From: Pat Aird
Sent: 13 June 2018 08:45
To: Karen Parsons
Subject: FW: FG/42/18/HH

From: [REDACTED]
Sent: 10 June 2018 20:03
To: Pat Aird
Subject: FG/42/18/HH

PROPOSED SITE PLAN

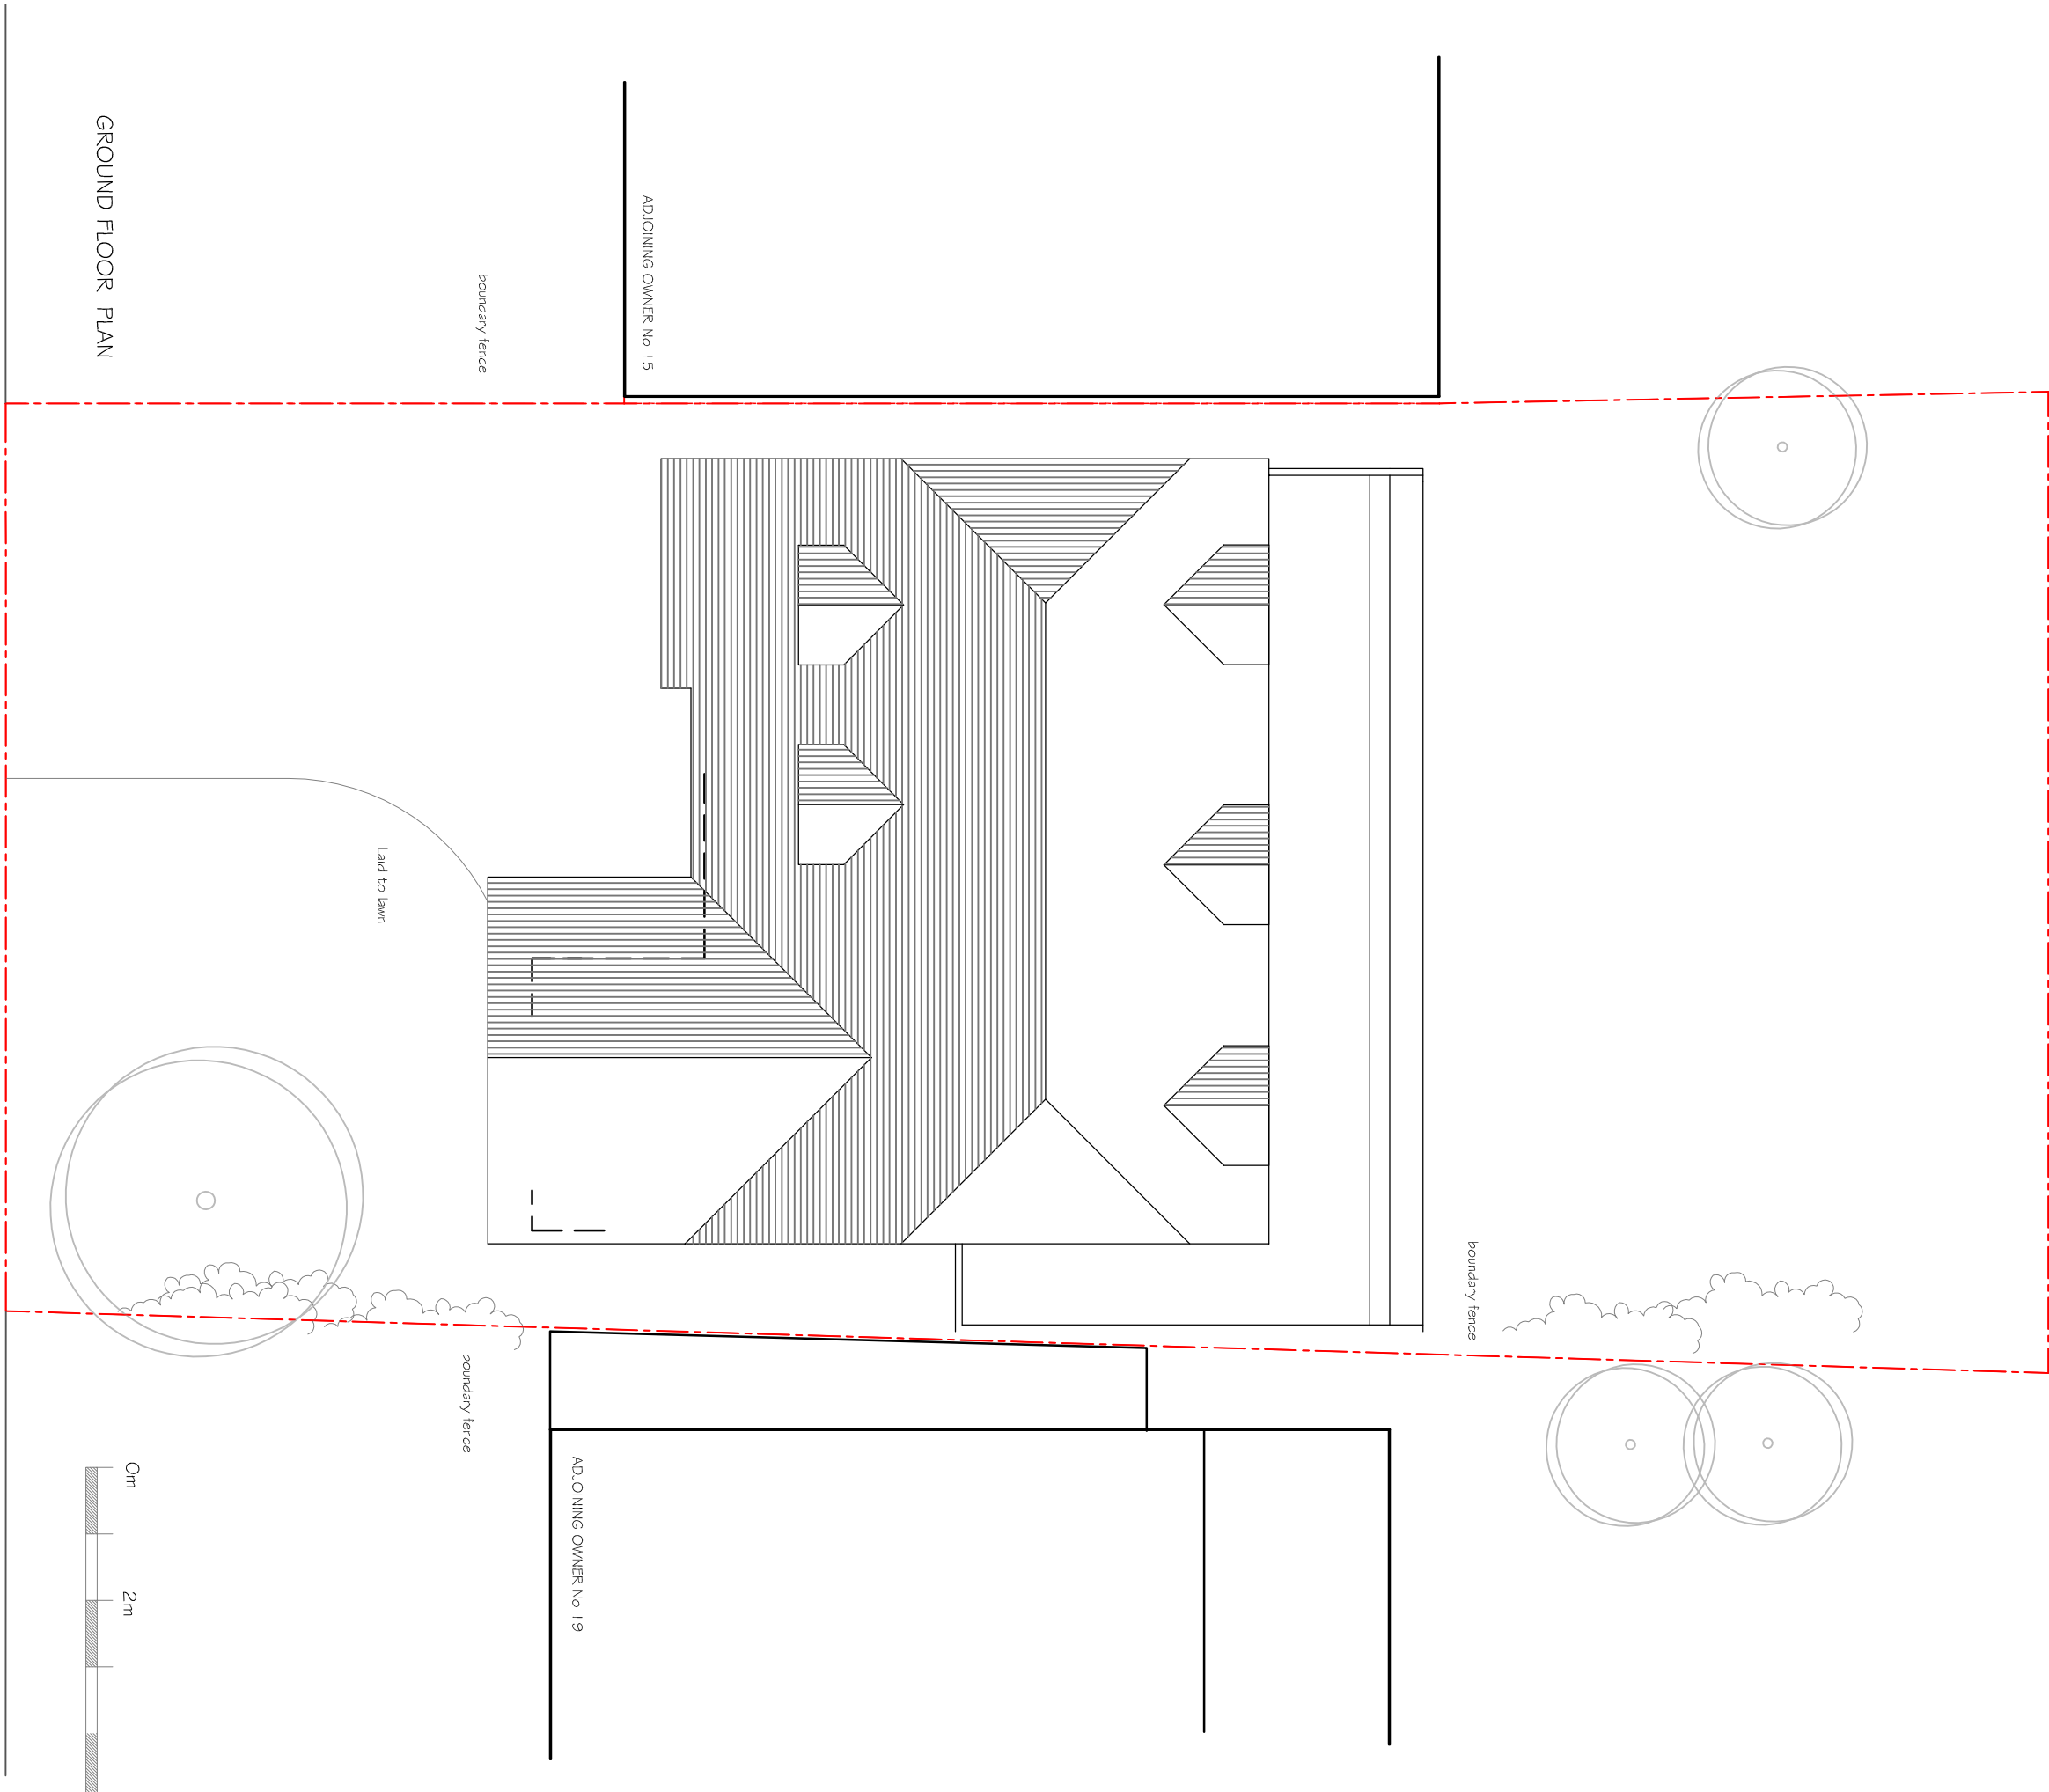
I am not sure of protocol or even if I can contact you, but I have subsequently noticed that the applicants suggest extending the parking area for 3/4 vehicles, however, you may have noticed that the vehicles on the plans submitted are completely out of scale. The parking area would have to be significantly wider than shown to park 4 vehicles, with a wider entrance. This would be unlike anything nearby, neighbouring properties are laid to pleasant gardens thus this would have a detrimental effect on the street scene.
